Application number: 2019/91609	
What is the application for?:	Outline application for erection of residential development
Address of the site or building:	adj, Marsh Conservative Club, Abb Street, Marsh, Huddersfield, HD1 4PB
Postcode:	HD2 1QN

SITE PLAN  
1:200

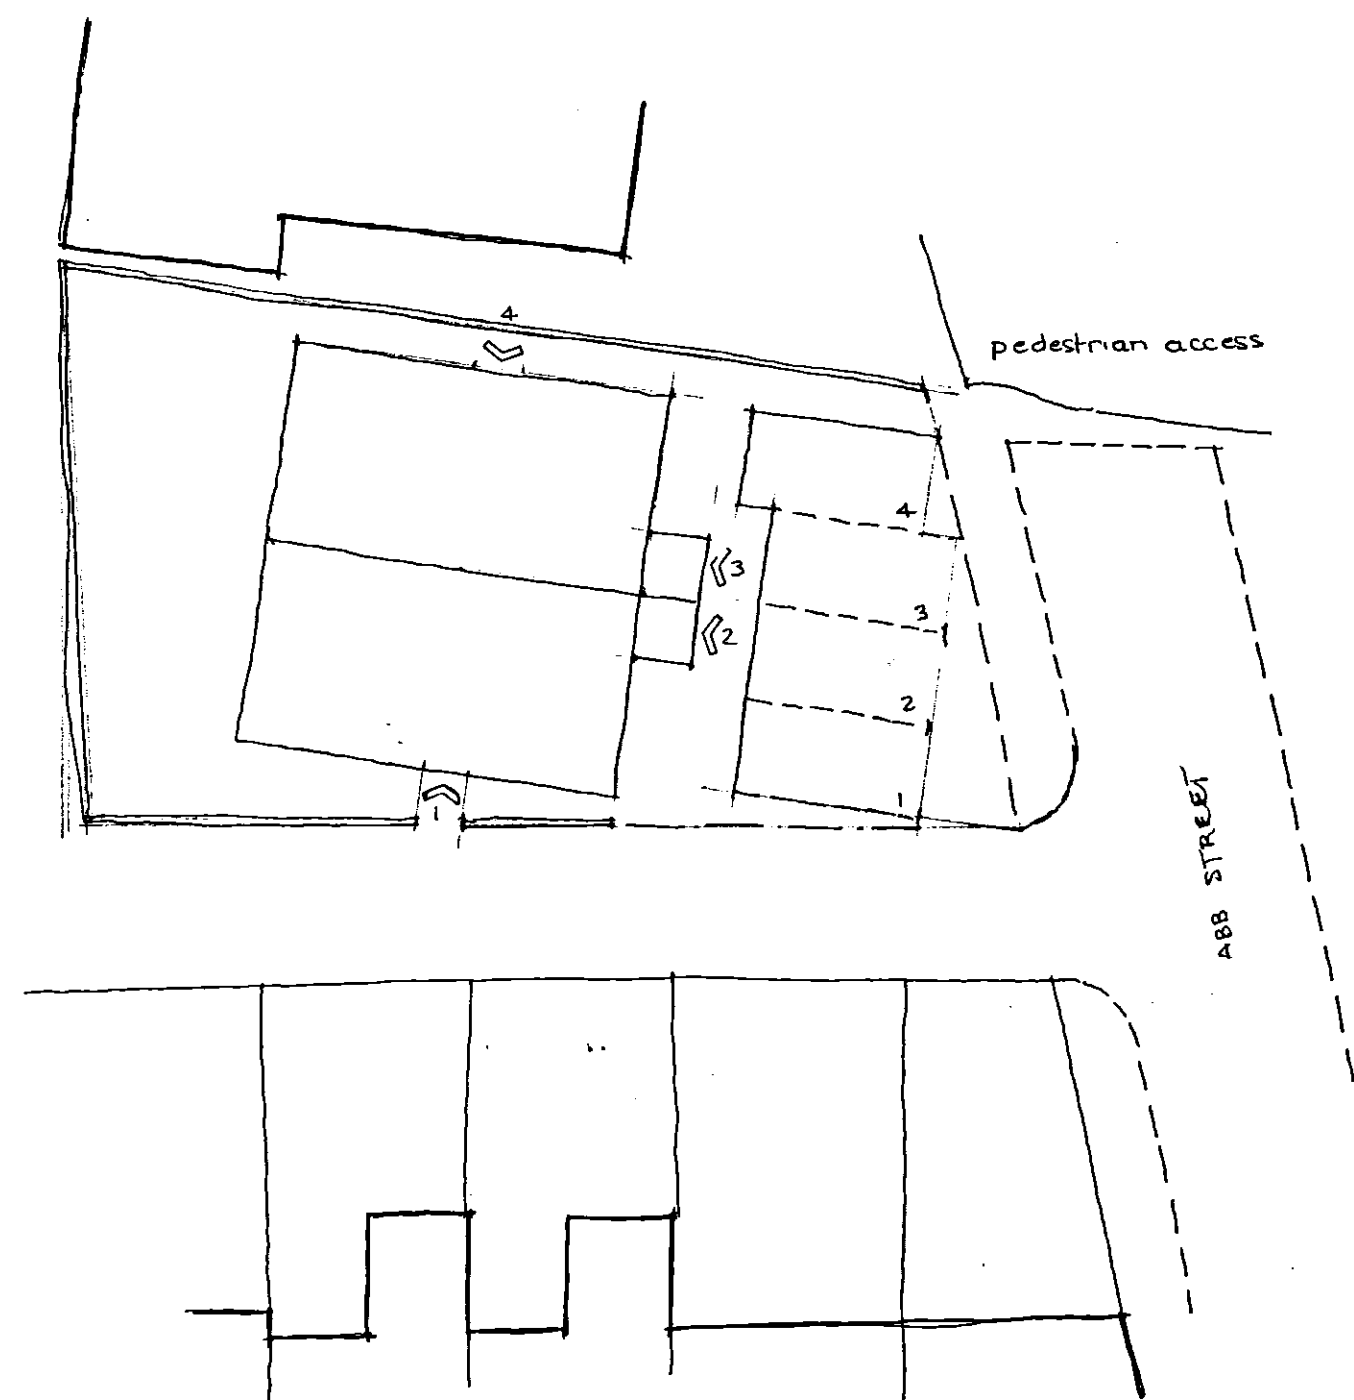
Type of comment: An objection
I am very concerned about the proposed access to the site. It appears that it would involve the loss of part of the pavement on Abb Street. Pedestrian access to the nearby Marsh Con Club is via this pavement. It is not the rear access of the Marsh Con Club, as stated in the report from Highways.
